Subject: Yew Tree House
Importance: High

16/00247/DISC of 16/00080/F

16/00250/DISC of 16/00081/LB

Section 1 Through Link

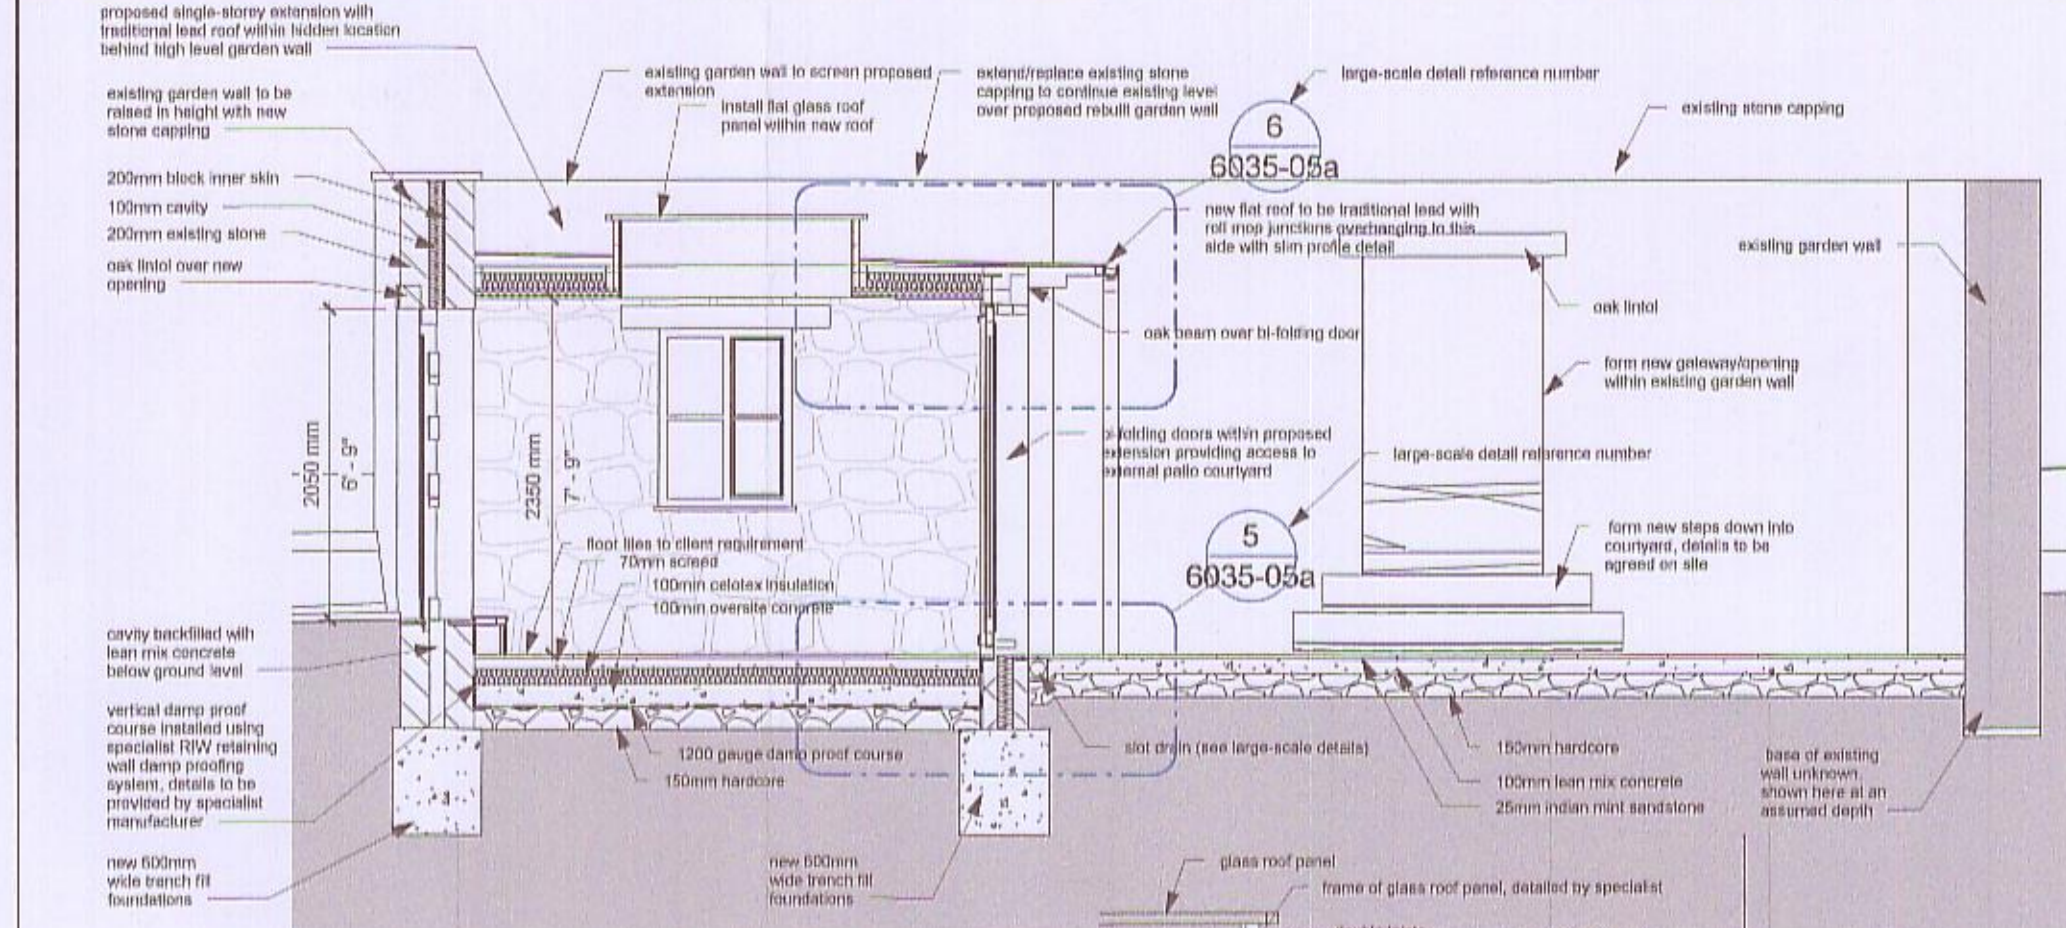
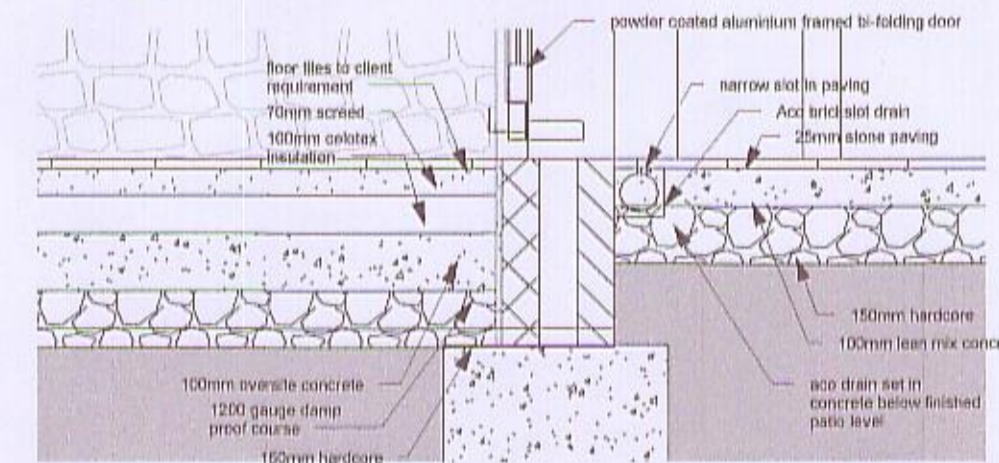
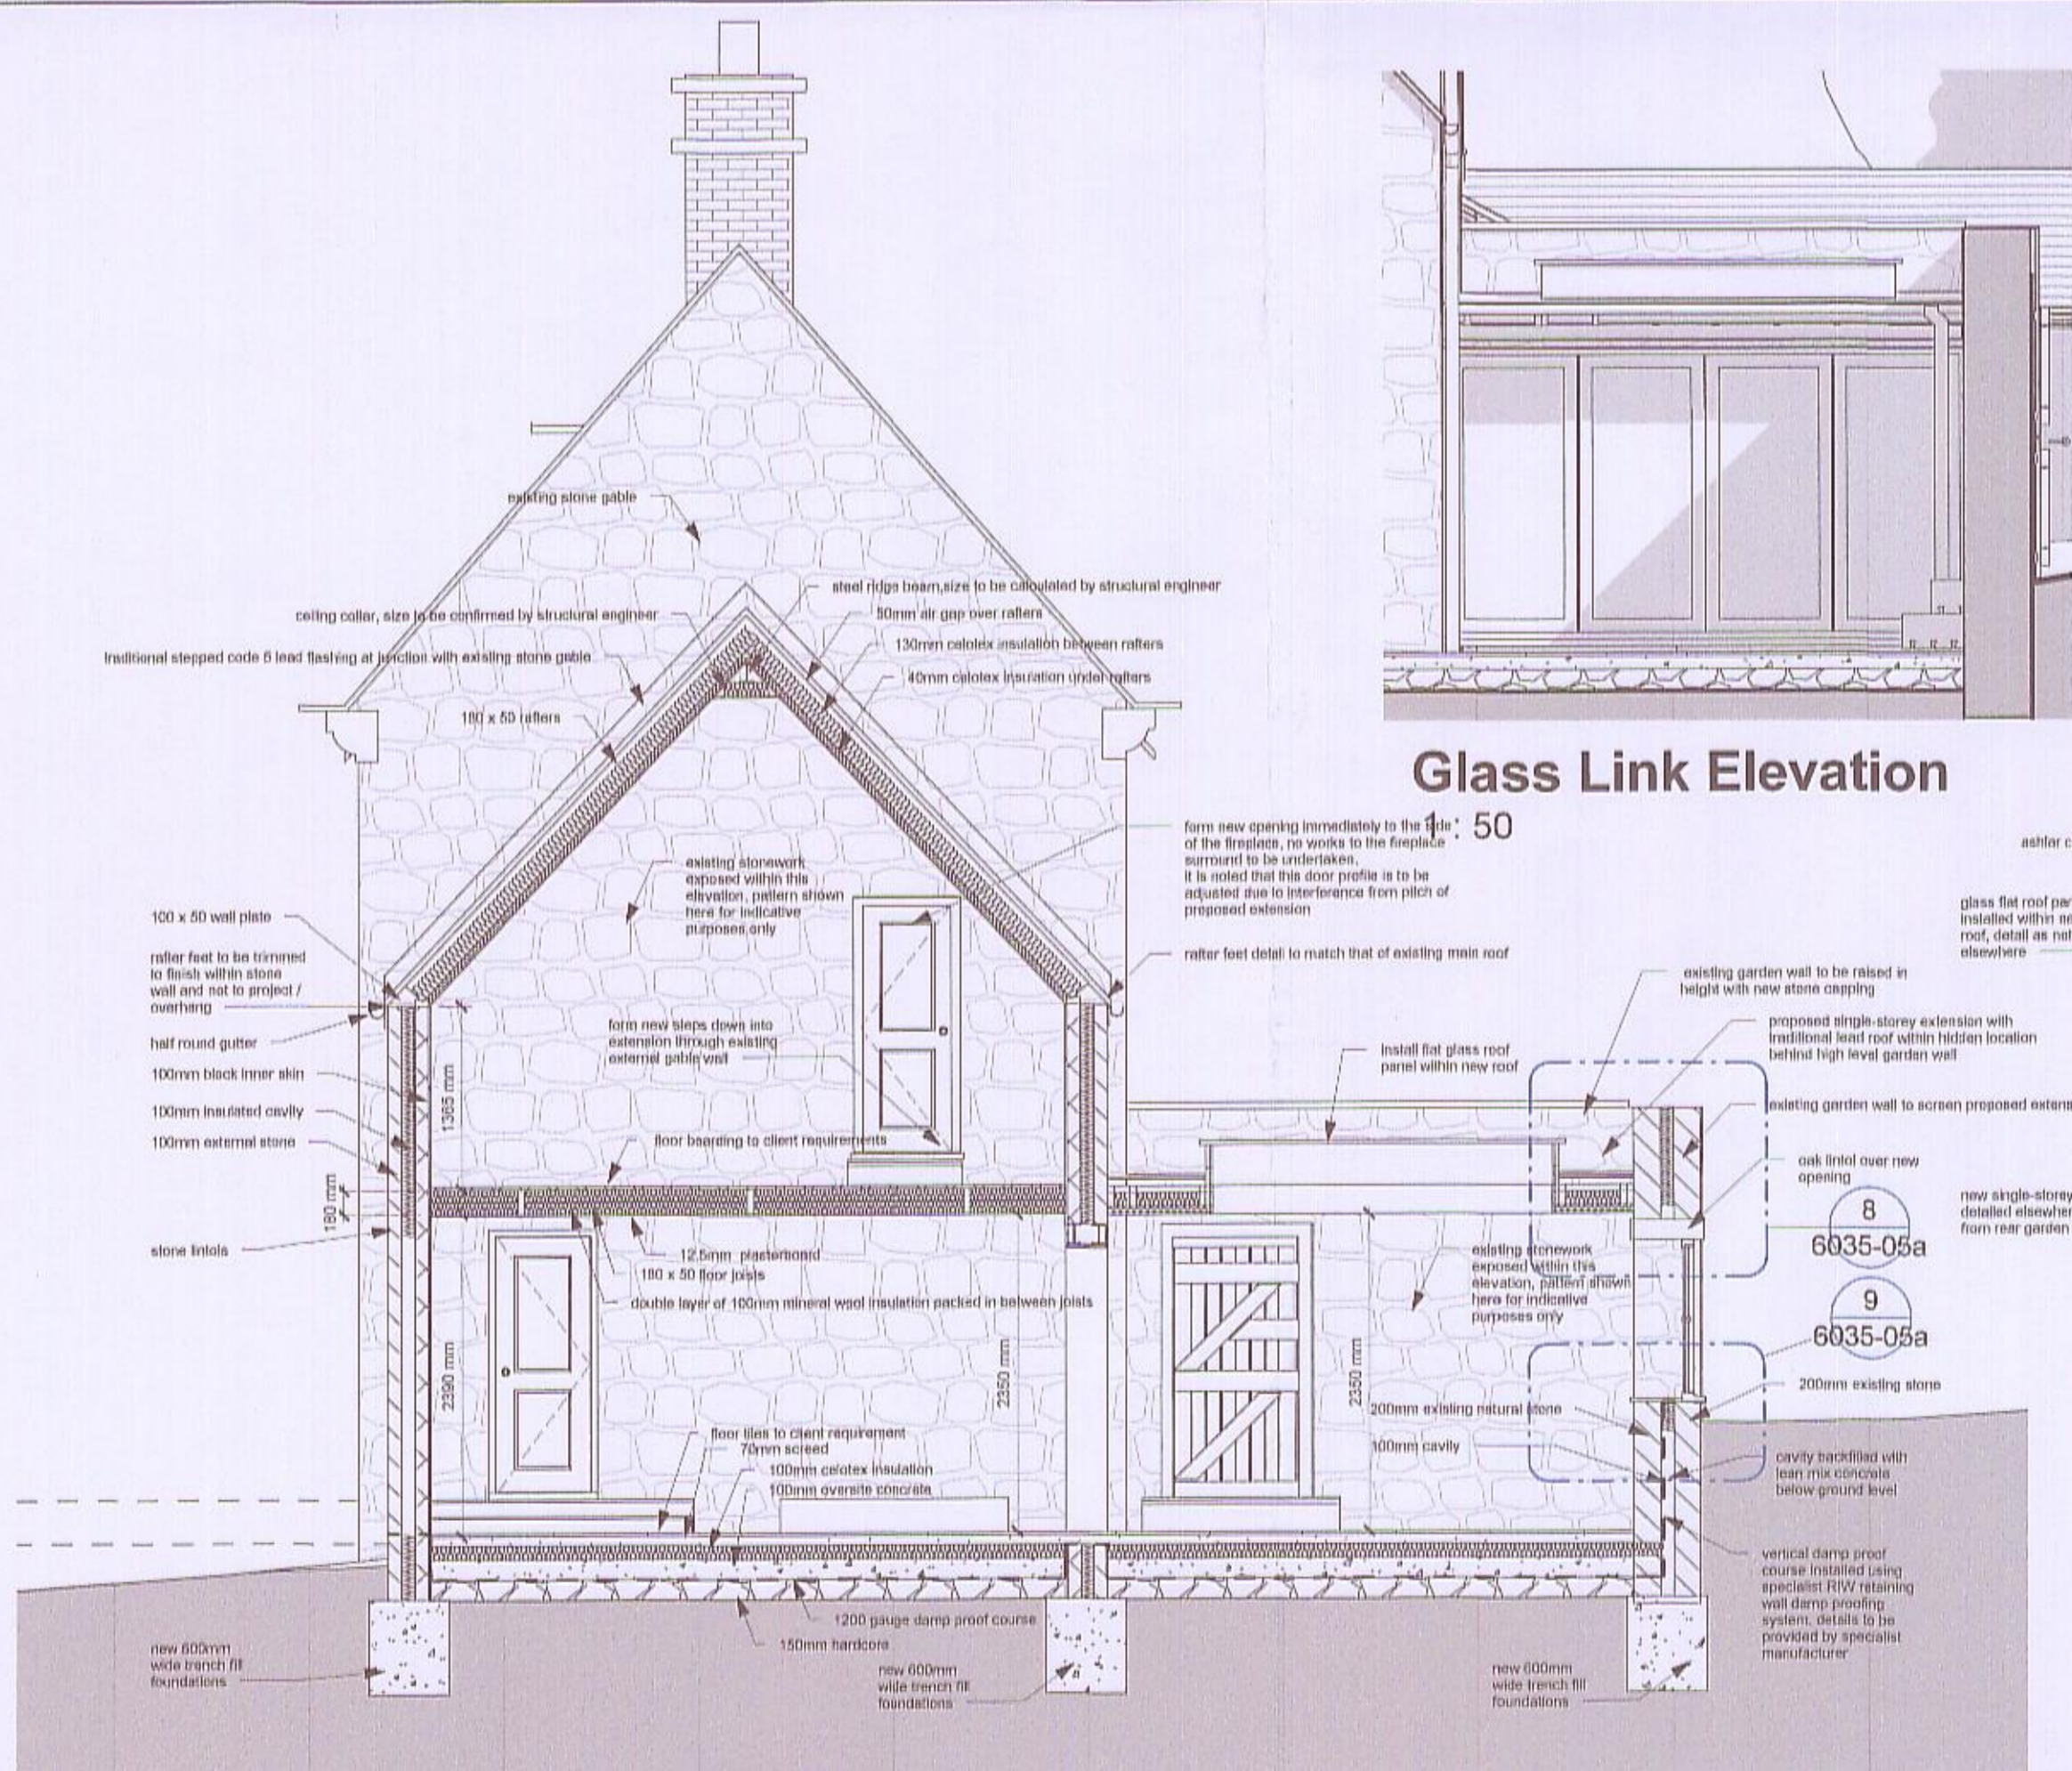
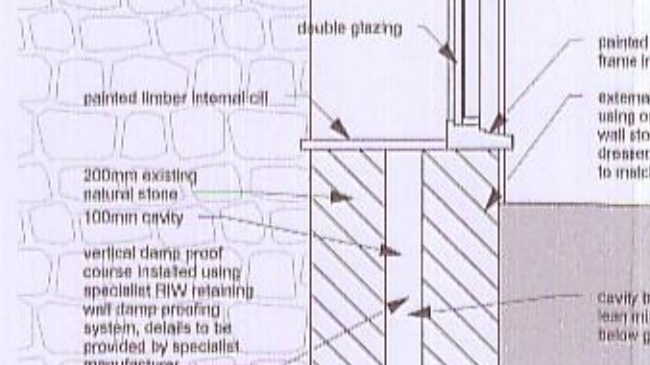
4 (glazed link and north garden wall) - The approved drawings showed the curtilage listed garden wall being underpinned, it has been **taken down without consent** and a revised drawing now shows it being rebuilt as a cavity wall faced both sides in stone to match existing rather than as a block inner face as first appeared on the Building regs drawings submitted as part of the current discharge application. This should have no blockwork in the construction, above or below ground. It should be clearly read as a continuation of the garden wall, with no vertical joint or change in course size/typical stone size found in the extant wall – it is suggested a further sample is now needed for this garden wall which can be built as part of the wall – the remainder of the wall should not be rebuilt without written confirmation that the sample is acceptable – lime mortar with no cement gauging to match original. The detail of the stone capping is not shown on the section?

LSA and Historic England Guidance for lead encourages boarding rather than plywood, there is no mention of building paper etc. What is the detail for the ventilation of the roof as it abuts the historic wall?

Where is the detail of the glass roof? The line drawing gives no detail and refers to 'detailed by specialist'.
